The Coal
Authority

Re: Planning application 2026/0034

Outline application for the erection of one dwelling with details of access and layout (other matters reserved) at Land to the west of Chapel Road, Pilley, Barnsley, S75 3AR

**Figure 2.6 Mine shaft locations record from CA report.**

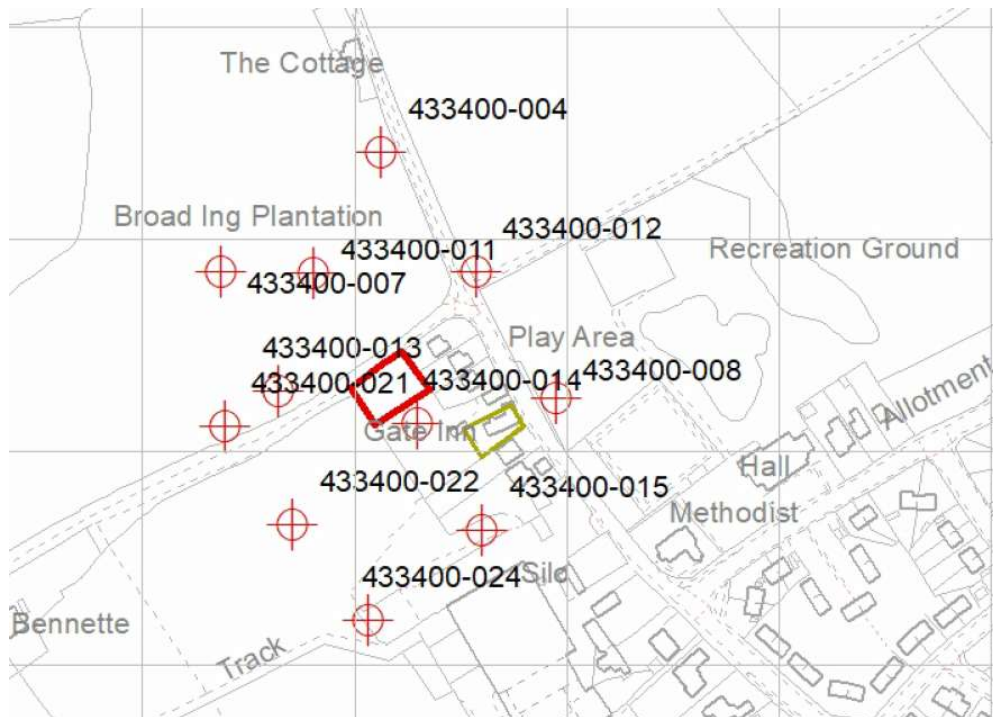
Our records also indicate that ironstone mining has taken place at shallow depth beneath the site and that the potential zone of influence of recorded off-site ironstone mine shaft 433400-014 encroaches into the site. It falls outside the remit of the Coal Authority to comment upon non-coal related mining activity. The LPA should therefore seek its own technical advice on the safety and stability risks posed by past ironstone mining activity that may affect the site and the implications it may have for the development proposal.

The application is accompanied by a Mining Risk Assessment report (November 2025, prepared by JNP Group). Based on a review of coal mining and geological information, the report identifies that the Joan coal seam is likely to be present beneath the site at shallow depth, underlain by recorded ironstone workings. It concludes that mine workings in these seams have the potential to pose a risk to the stability of the site. It also identifies the potential for the presence of unrecorded mine shafts within the site.

- 1. *No above ground development shall commence until;***
 - a) a scheme of intrusive investigations has been carried out on site to establish the risks posed to the development by past coal mining activity; and***
 - b) any remediation works and/or mitigation measures to address land instability arising from coal mining legacy, as may be necessary, have been implemented on site in full in order to ensure that the site is made safe and stable for the development proposed.***
